Biodiversity and Conservation Division Review of Environmental Impact Statement – New Warnervale Public School (SSD 9439)

BCD has reviewed the Environmental Impact Statement, including relevant appendices, annexures, attachments and parts of the document titled '*Environmental Impact Statement, The New Primary School at Warnervale*' (prepared by Creative Planning Solutions and dated August 2019) in relation to impacts on biodiversity, flooding and flood risk.

New Warnervale Public School– Environmental Impact Statement

**Table 4: Plant Community Types within the Development Site**

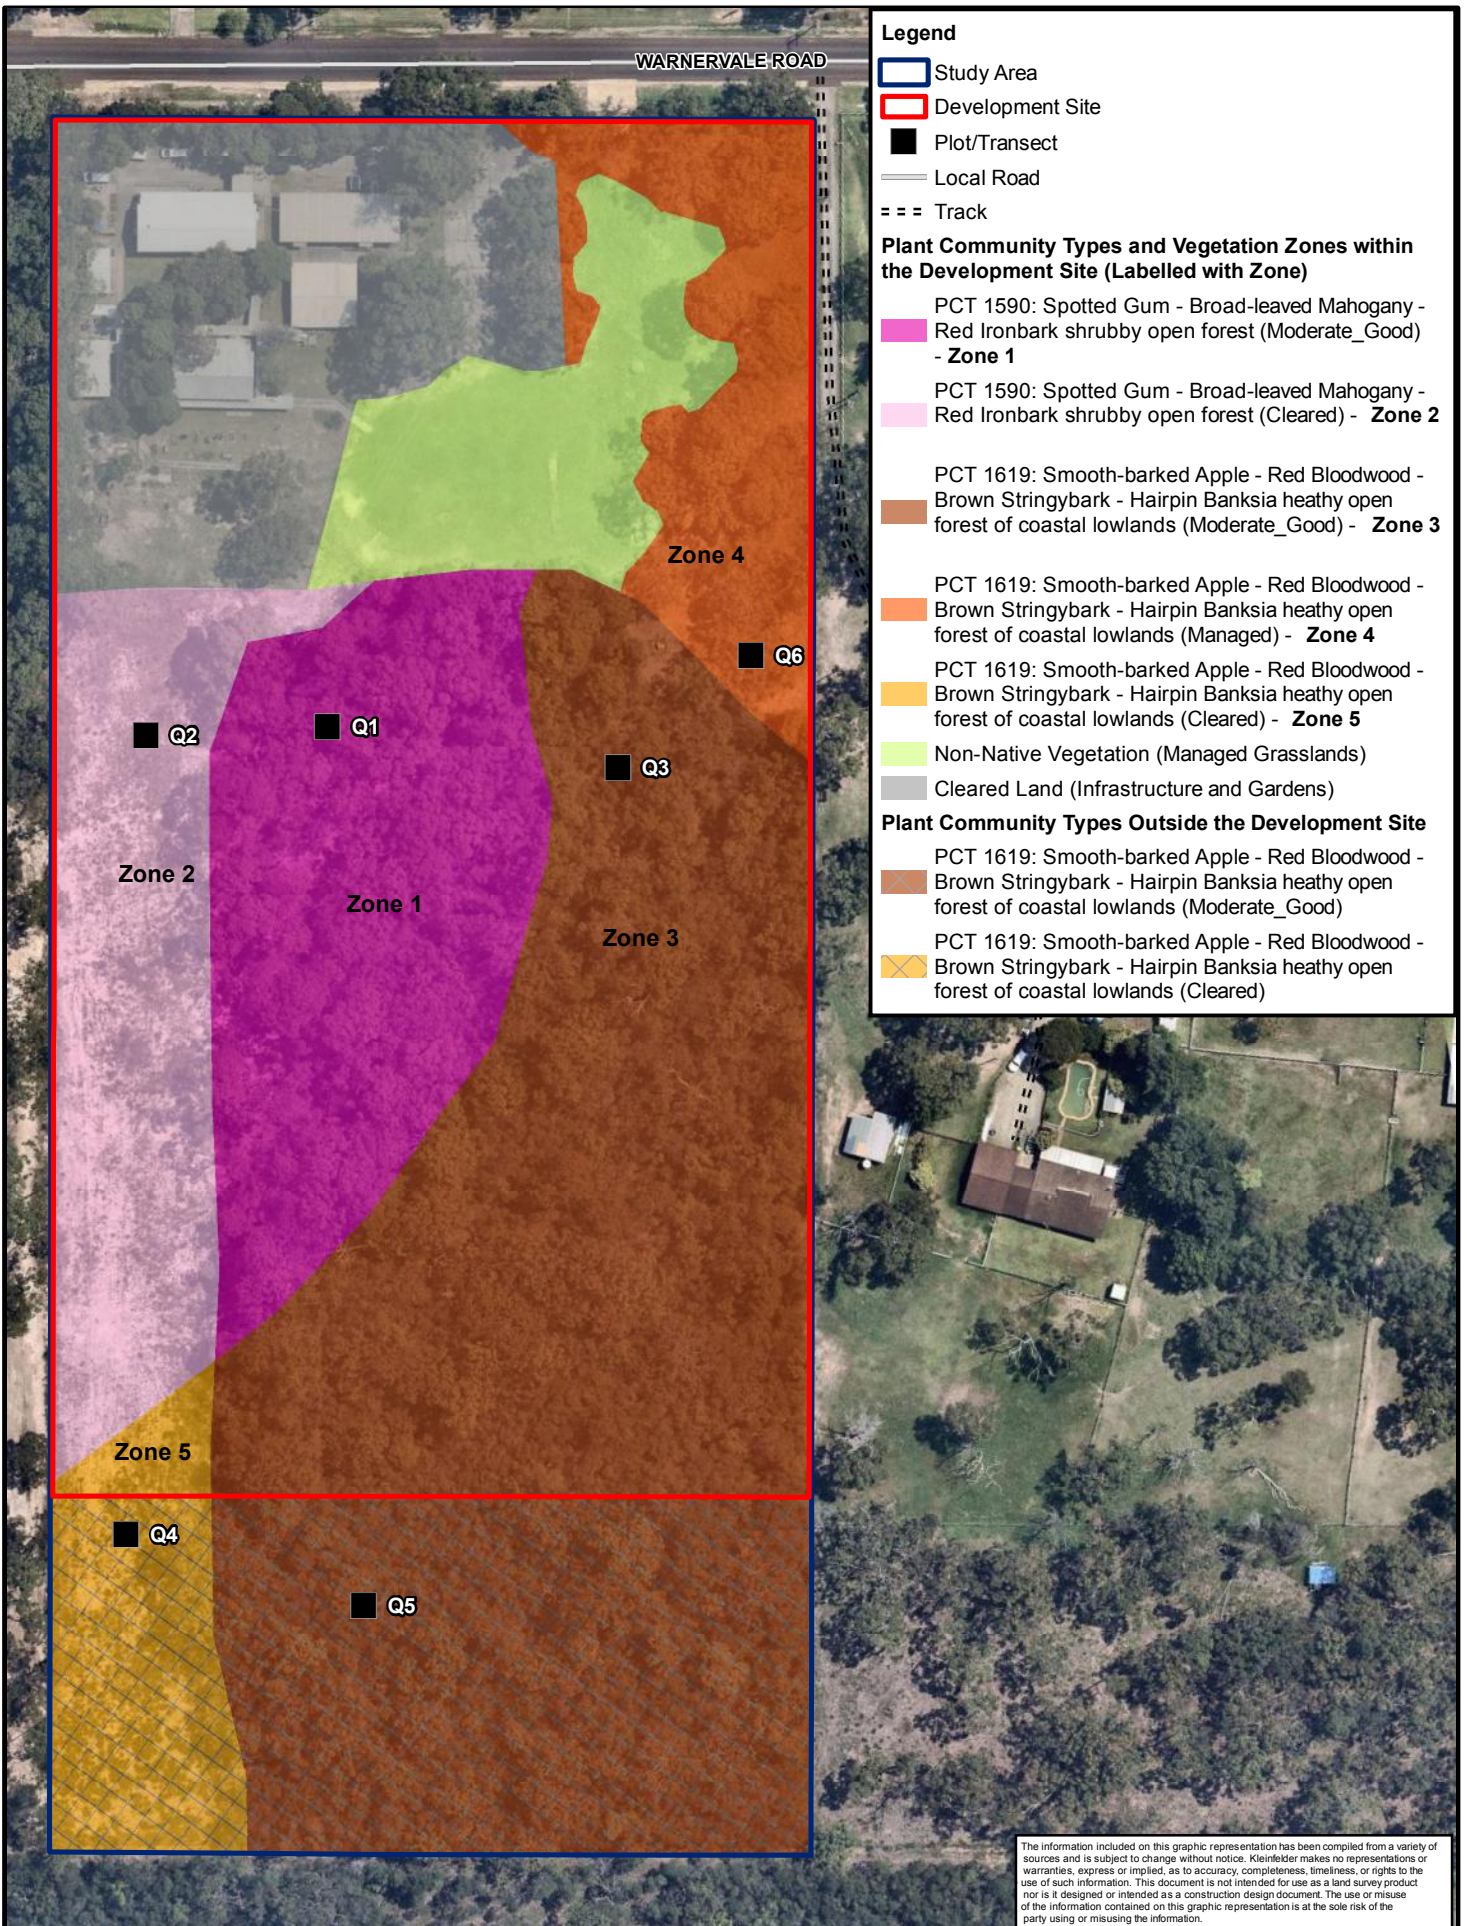
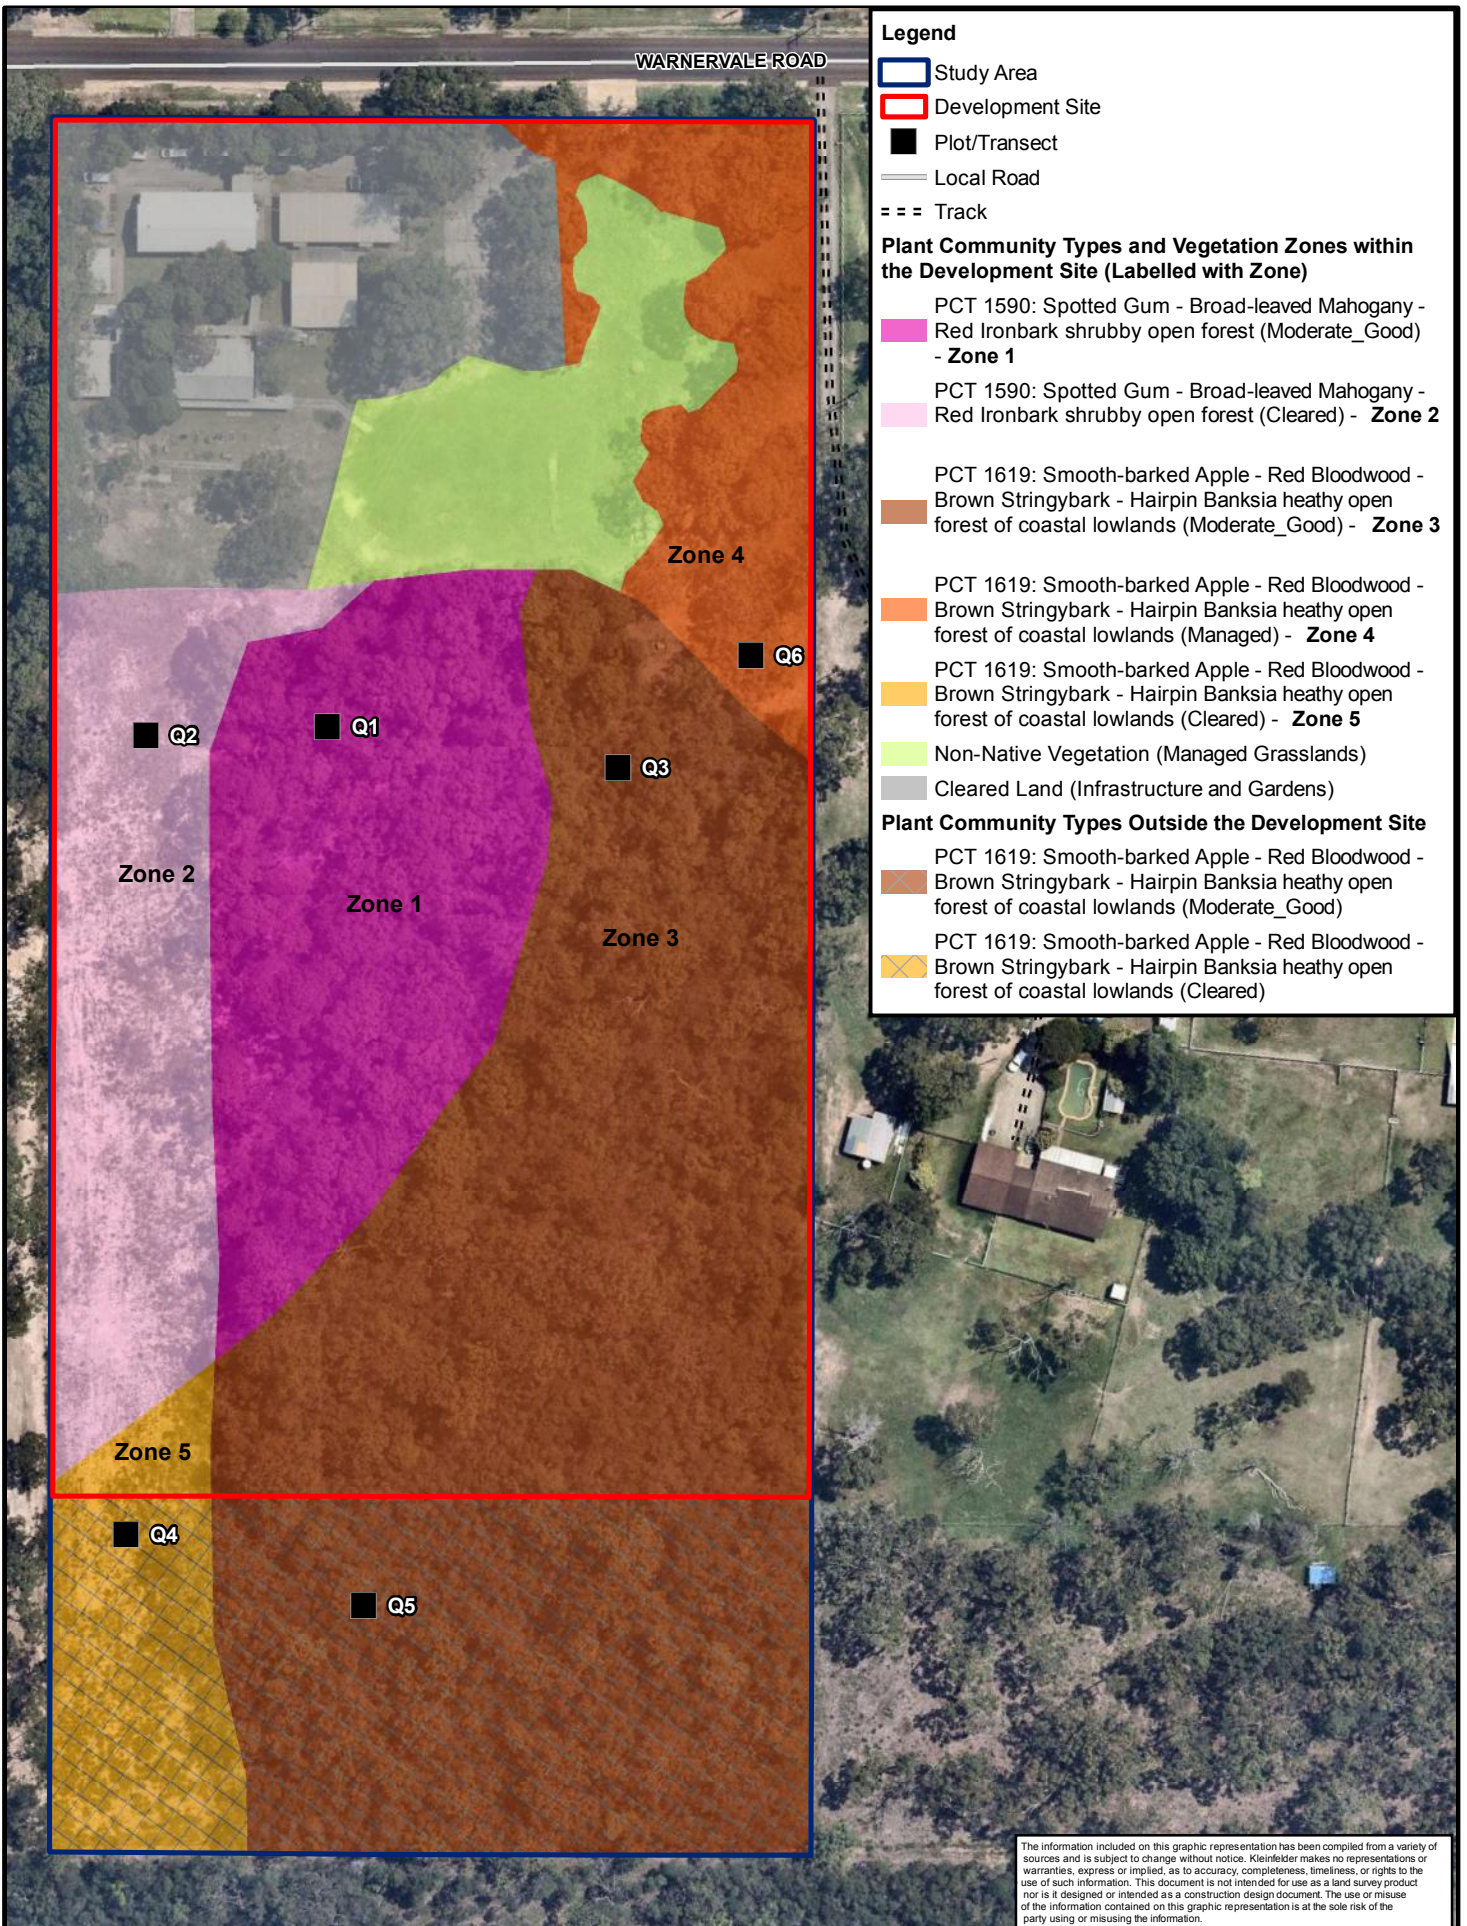
1. Clarification is sought regarding Plant Community Type 1590 on site to determine if it forms part of the Lower Hunter Spotted Gum Ironbark Forest in the Sydney Basin and NSW North Coast Bioregions Threatened Ecological Community

The Biodiversity Development Assessment Report (BDAR) maps Plant Community Type (PCT) 1590 spotted gum- broad-leaved mahogany- red ironbark shrubby open forest across the site. The PCT 1590 on site occurs on Triassic Narrabeen geology and contains flora species characteristic of Lower Hunter Spotted Gum Ironbark Forest in the Sydney Basin and NSW North Coast Bioregions (LHSGIB), which is a Threatened Ecological Community (TEC) listed on Schedule 2 of the Biodiversity Conservation Act (BC Act). Clarification is sought to determine if PCT 1590 on site forms part of the LHSGIB TEC. Any justification provided should reference the NSW Scientific Committee Final Determination for LHSGIB TEC (31/05/2019). If PCT 1590 on site forms part of LHSGIB TEC, the relevant sections of the BDAR should be updated to reflect this.

BCD recommends that justification is provided demonstrating why PCT 1590 does not form part of the LHSGIB TEC.
